From: Carol Reynolds
Sent: 02 September 2021 11:23
To: Anita Gardner <Anita.Gardner@arun.gov.uk>
Subject: A/180/21/DOC Condition 6 Construction Management Plan. Mayflower Way

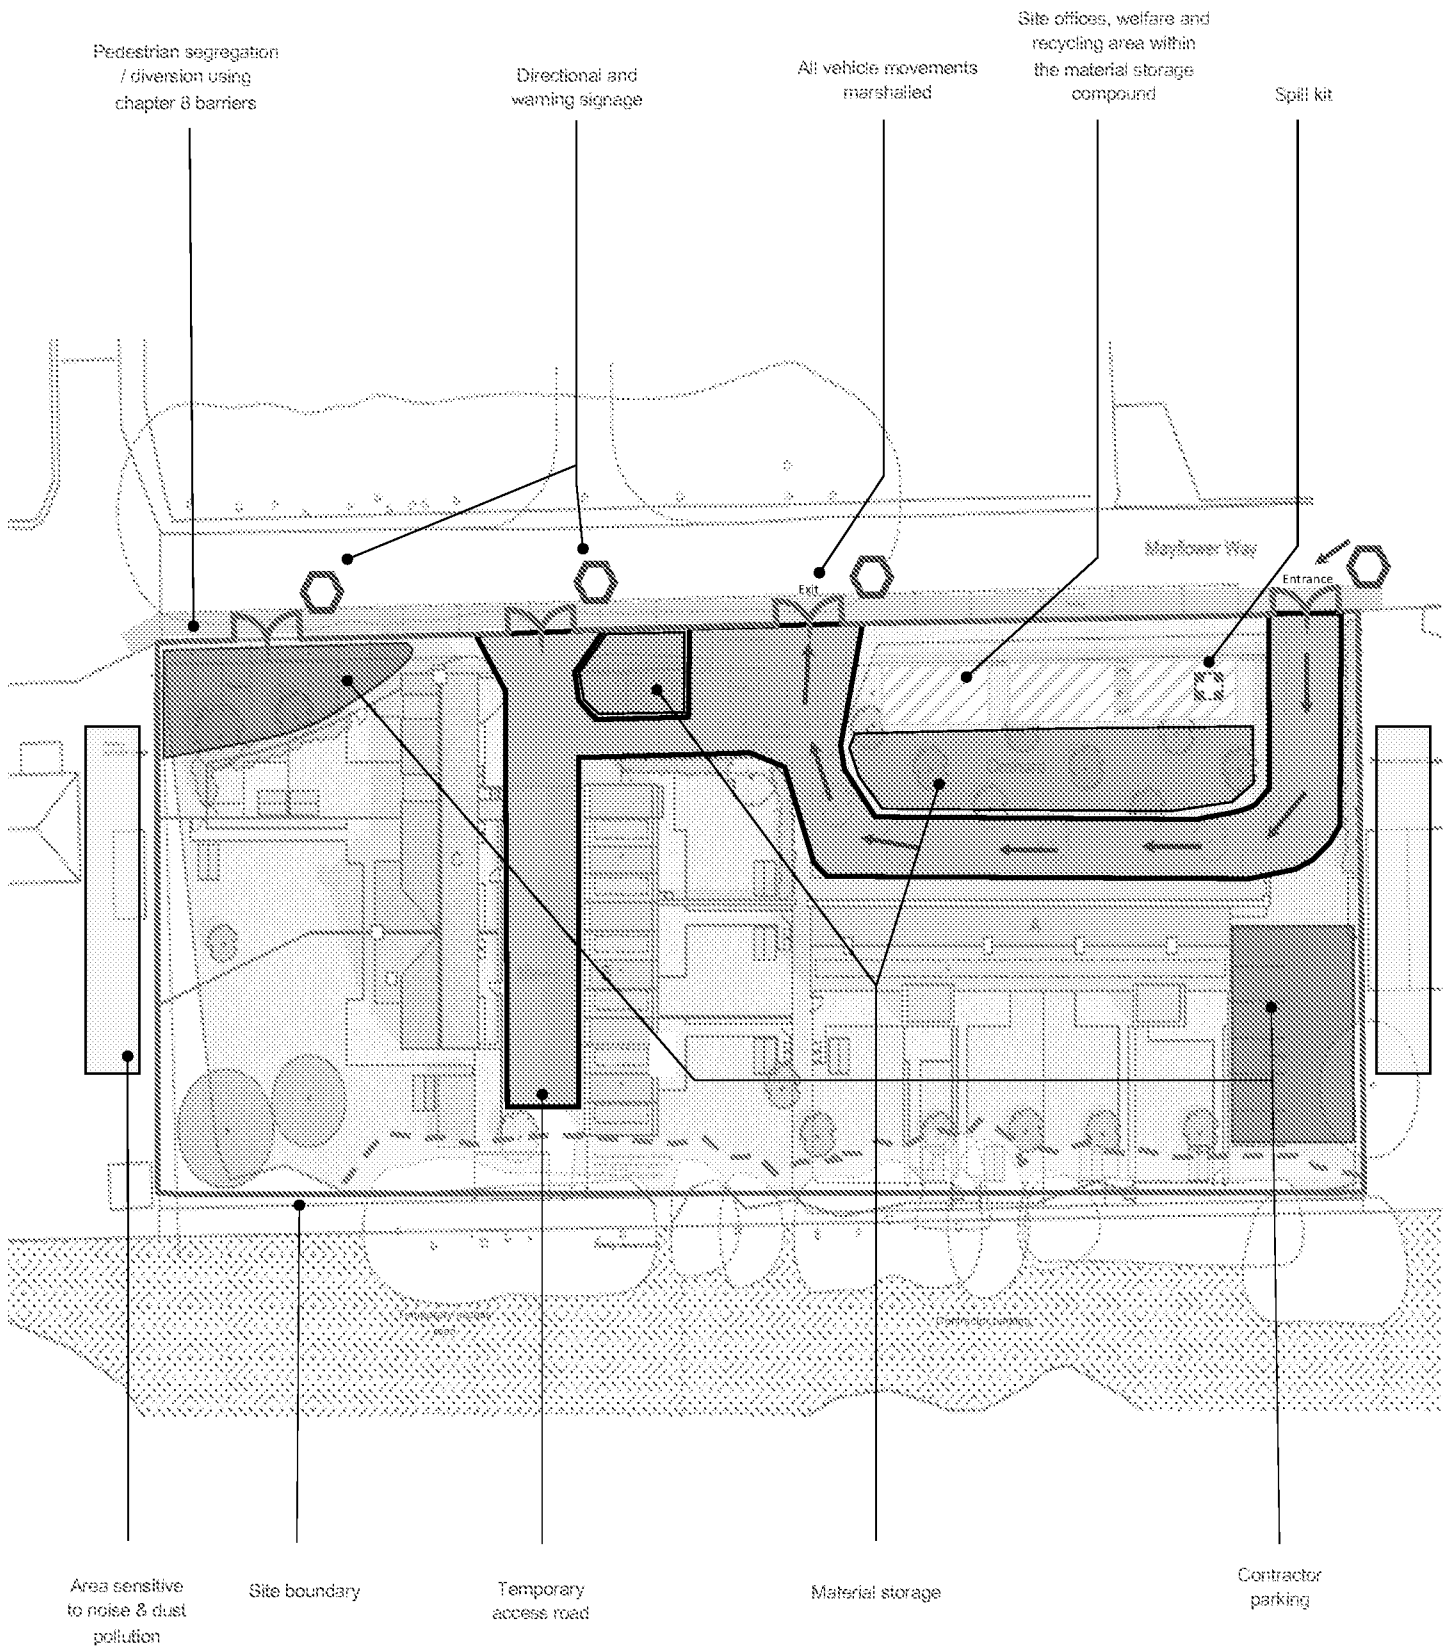
Environmental Health: No agreement to discharge of Condition 6. The applicant will be aware of the predominantly peaceful nature of this area. It is therefore of concern to note that both access to the site materials storage area, (which will include HGV deliveries/taking away) and to contractor car parking is proposed along the boundary with a bungalow/housing to the immediate east of the proposed new housing. There is a similar, but smaller, area of contractor parking proposed immediately onto the boundary with that property to the immediate west of the site.

The location of the site access way/materials storage is therefore far from ideal and in my opinion likely to result in noise detriment/nuisance to nearby sensitive receptors. I would request for the site access way and main materials store to be repositioned to a more central position along Mayflower Way. Perhaps, it would then be possible for the main area of contractor parking to be brought forward towards Mayflower Way to form a buffer to this bungalow.

Please could the applicant describe the type of vehicles which will be included in 'contractor parking' ie will this be for vans and private cars alone/other.
